Civil Engineering Impacts on Existing Tree Cover

**Hammond Ground, Read in respect of
Application No. 3/2026/0356**

**For the erection of 77 no. dwellings and creation of
community parkland with vehicular access from Whalley
Road and associated infrastructure, parking and landscaping**

Technical Working Notes – Earthworks, Trees and Enabling Works

ROAD 5 - LONGSECTION
SCALE: H 1:500,V 1:100, DATUM: 110.000

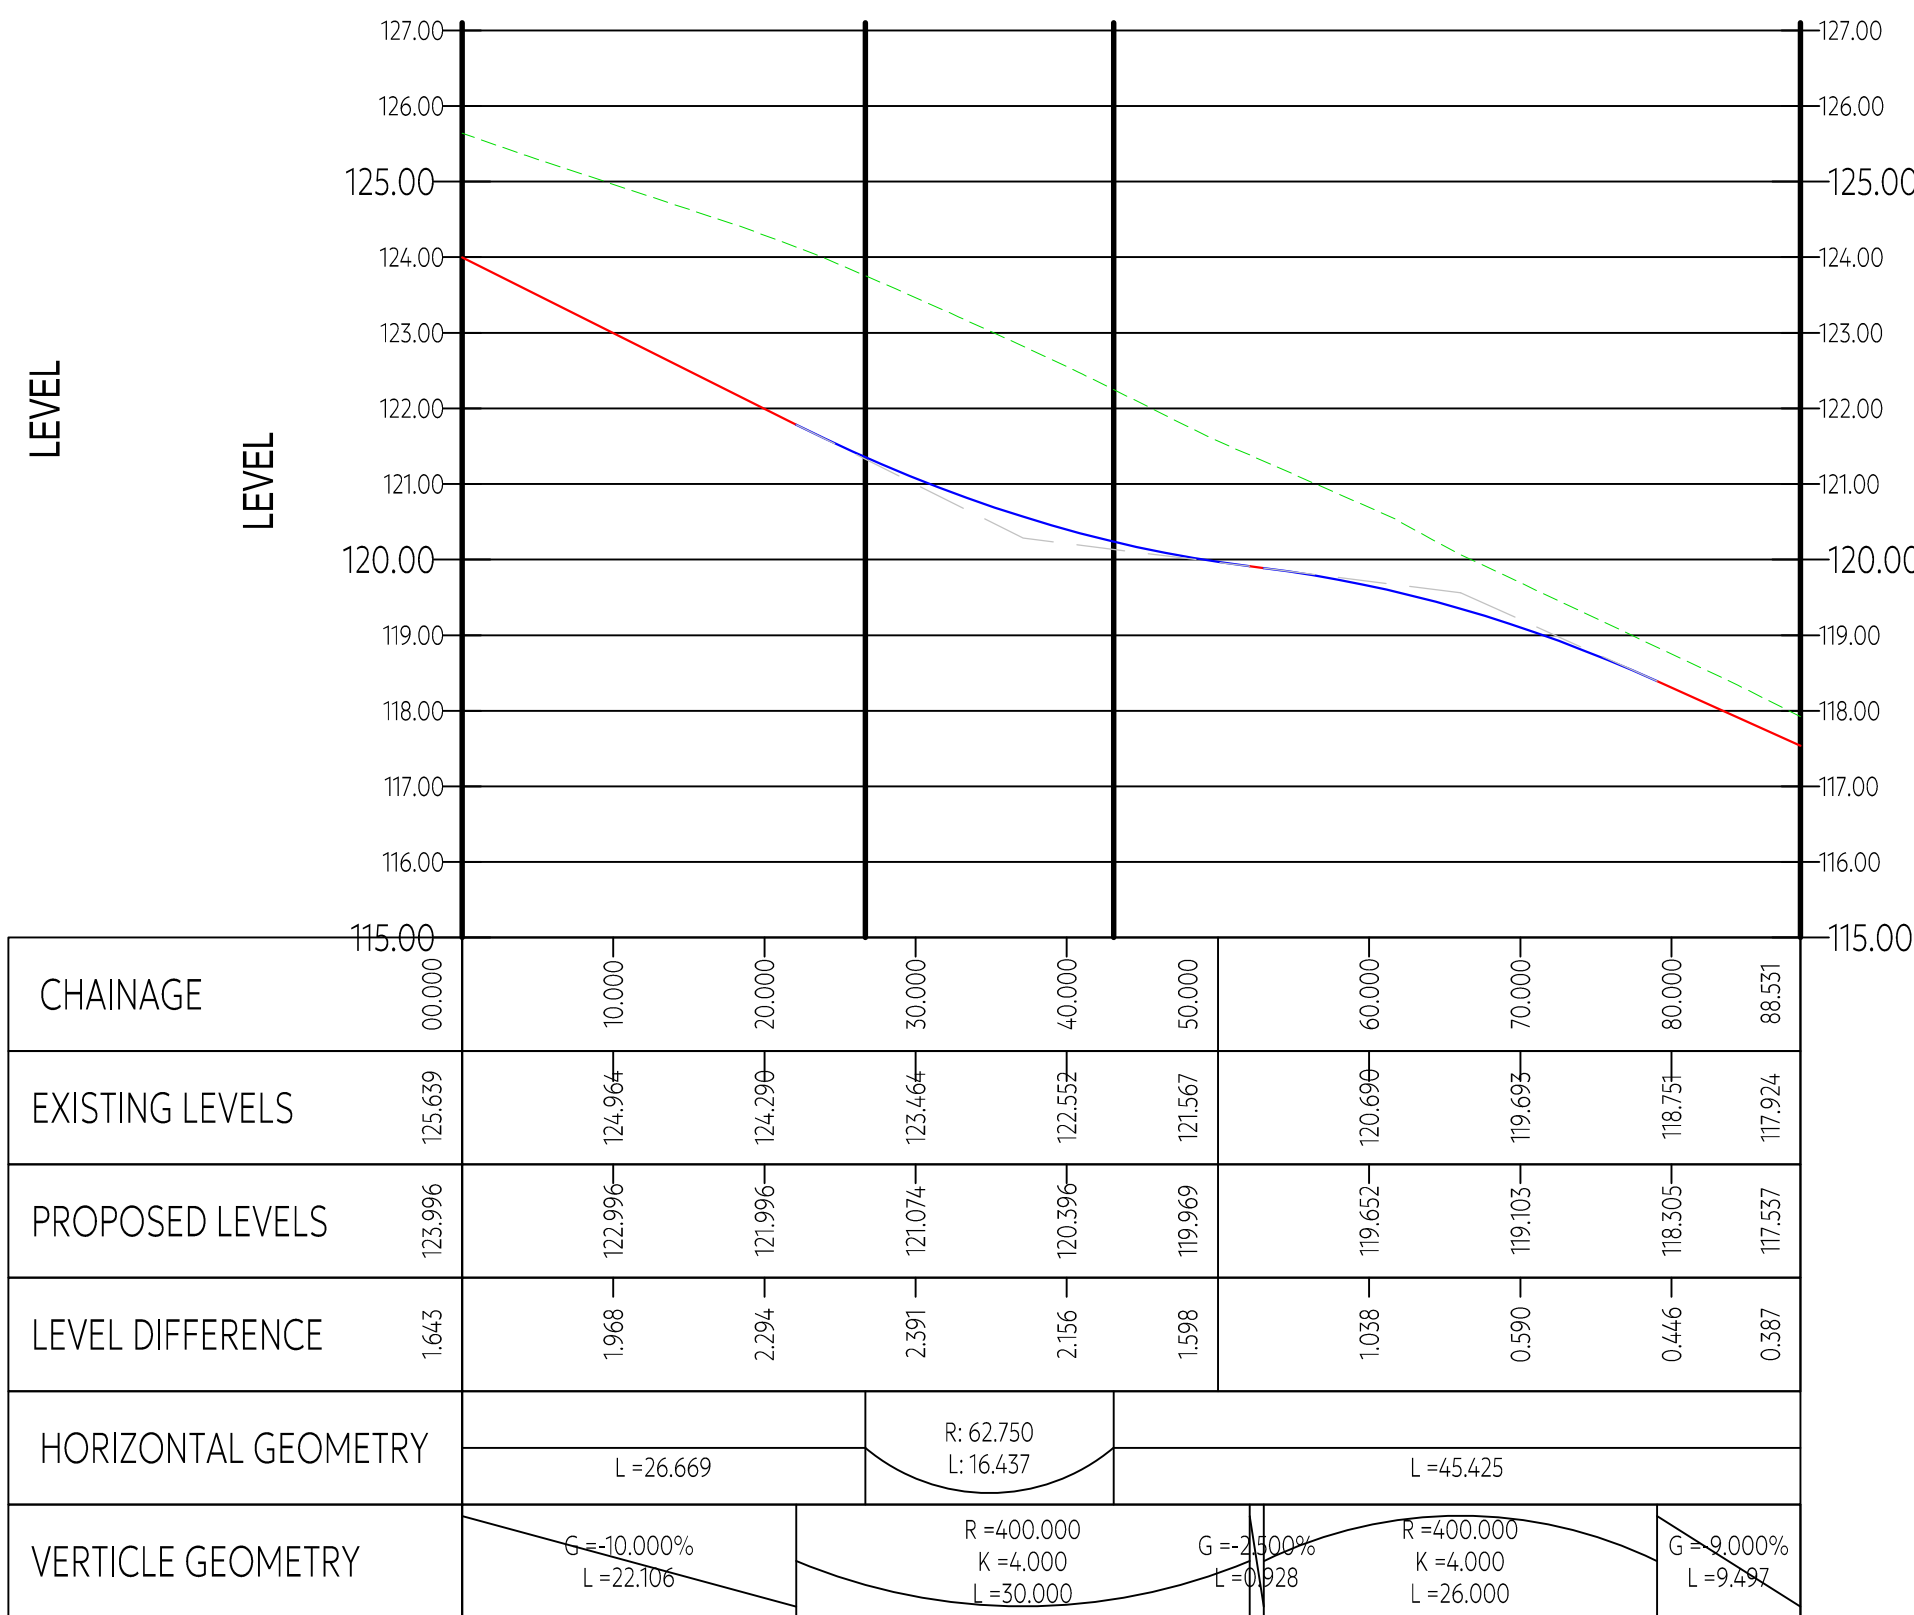
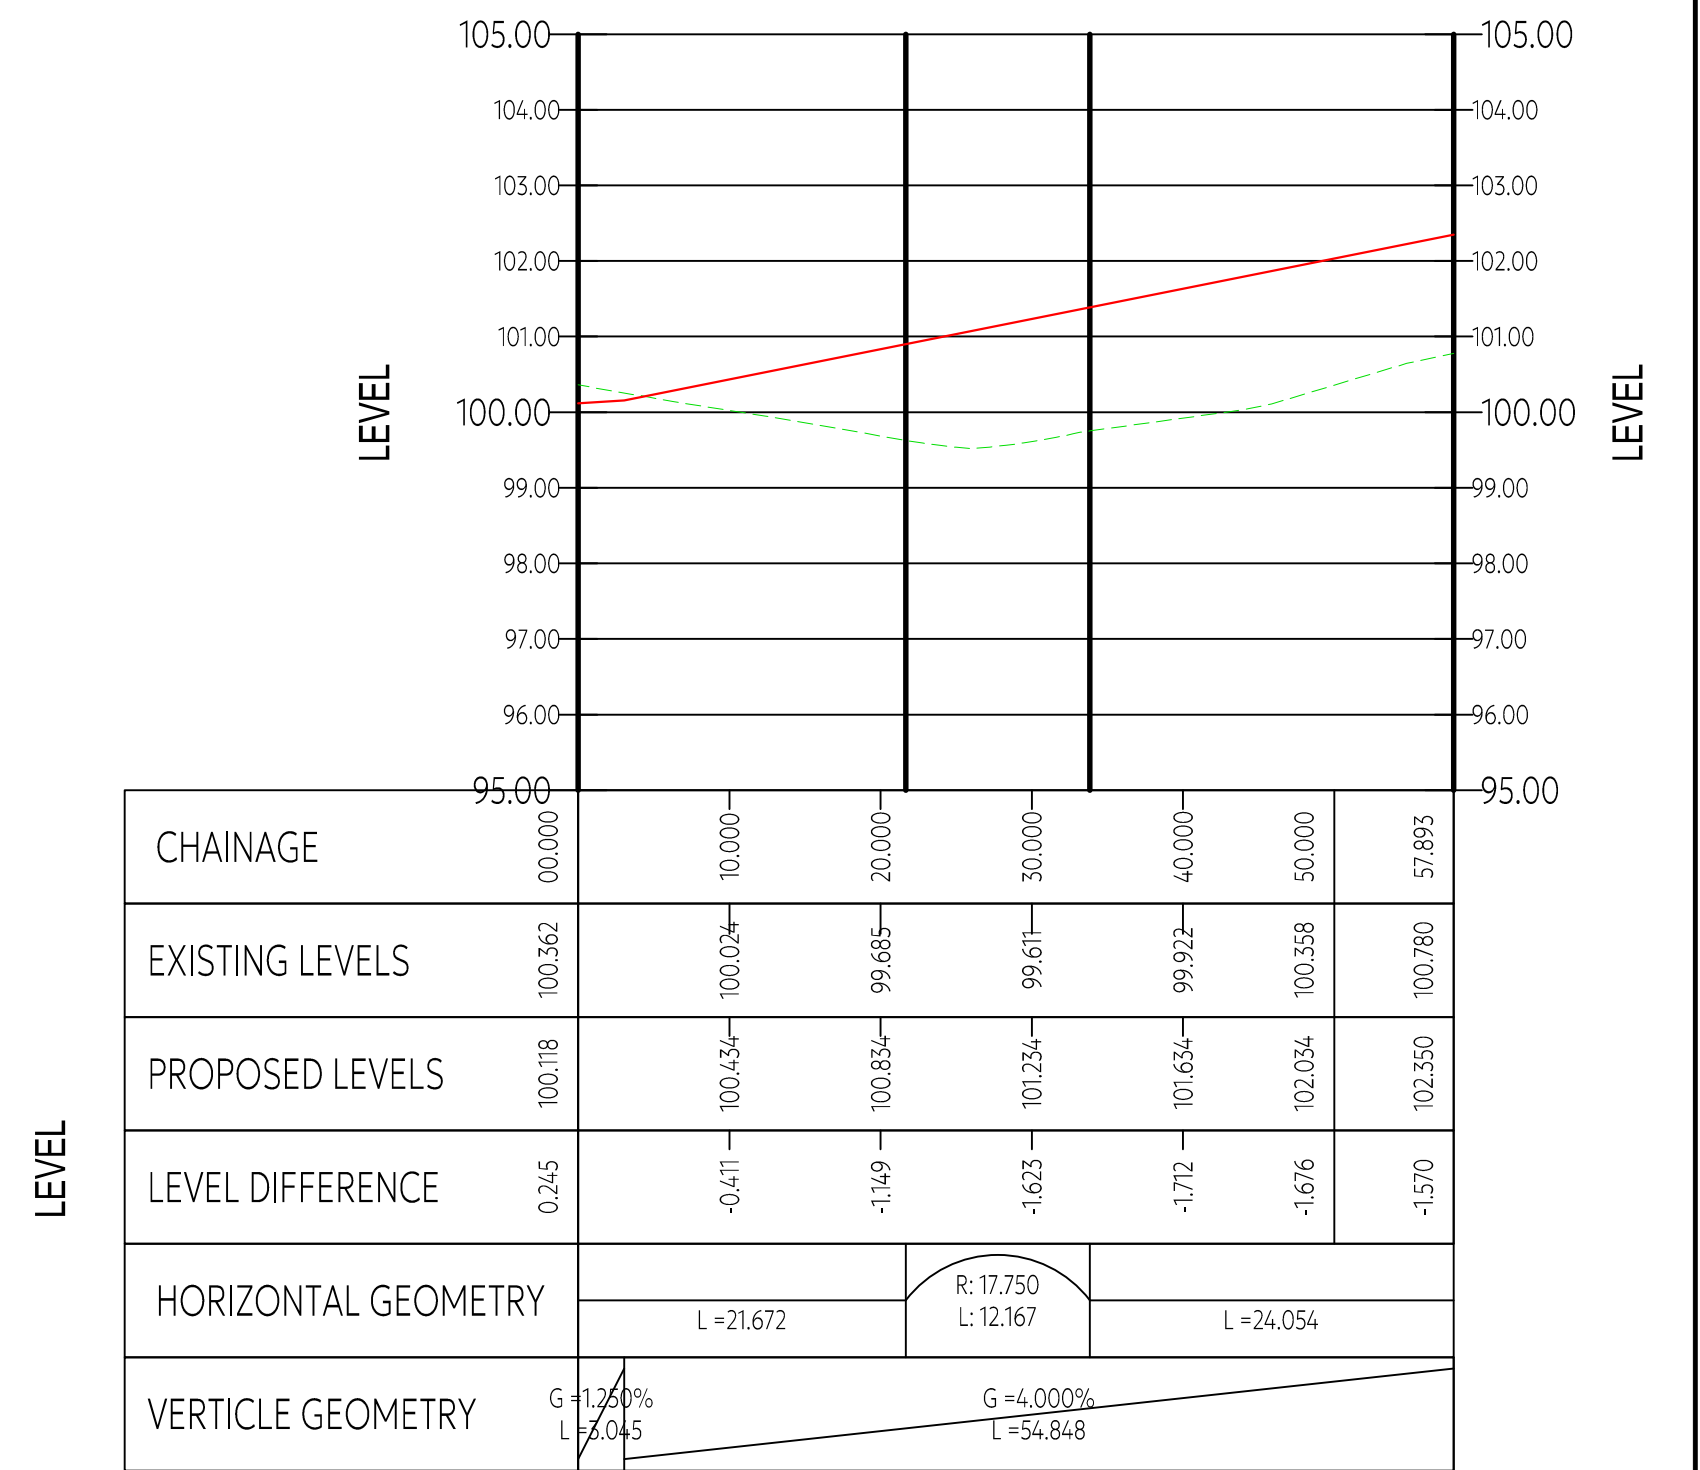
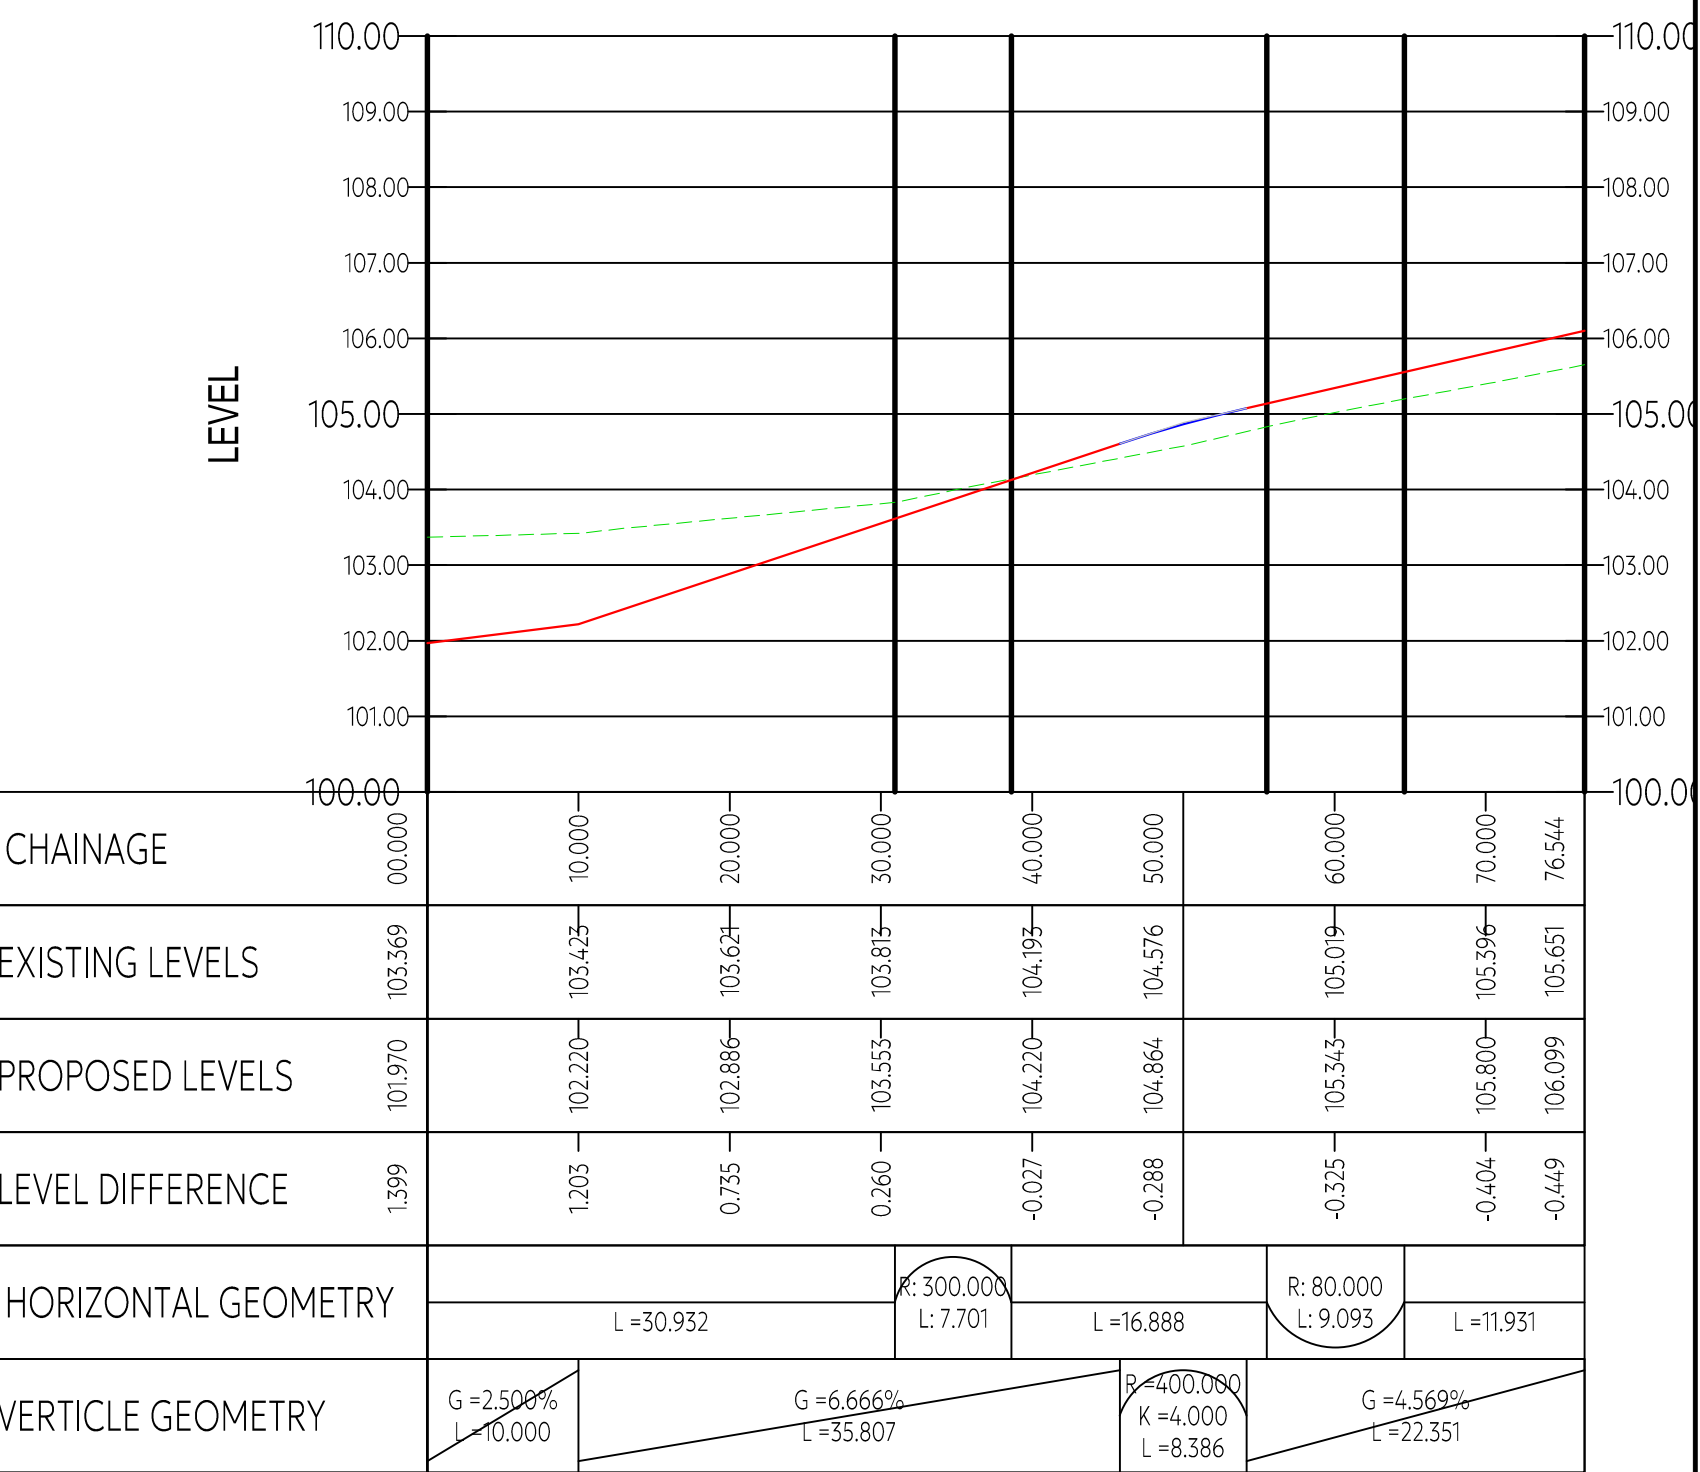
- The highway sections show significant differences between existing and proposed ground levels in several locations, including areas where approximately 3-4 metres of level change appears to be proposed.

- The highway section indicates approximately **3 metres** difference between the existing and proposed ground levels.
- The adjacent External Works drawing shows a retained mature tree within close proximity to these proposed works.
- The submitted drawings also indicate that existing ground levels around retained trees should remain unchanged.
- Based on the information currently submitted, I cannot reconcile how these proposed earthworks can be undertaken whilst maintaining the existing ground levels around the retained tree.
- Additional engineering and arboricultural detail would help explain how this constraint is intended to be managed.

How can the proposed changes in ground levels be achieved whilst maintaining the existing ground levels around this retained tree, as indicated elsewhere on the submitted drawings?
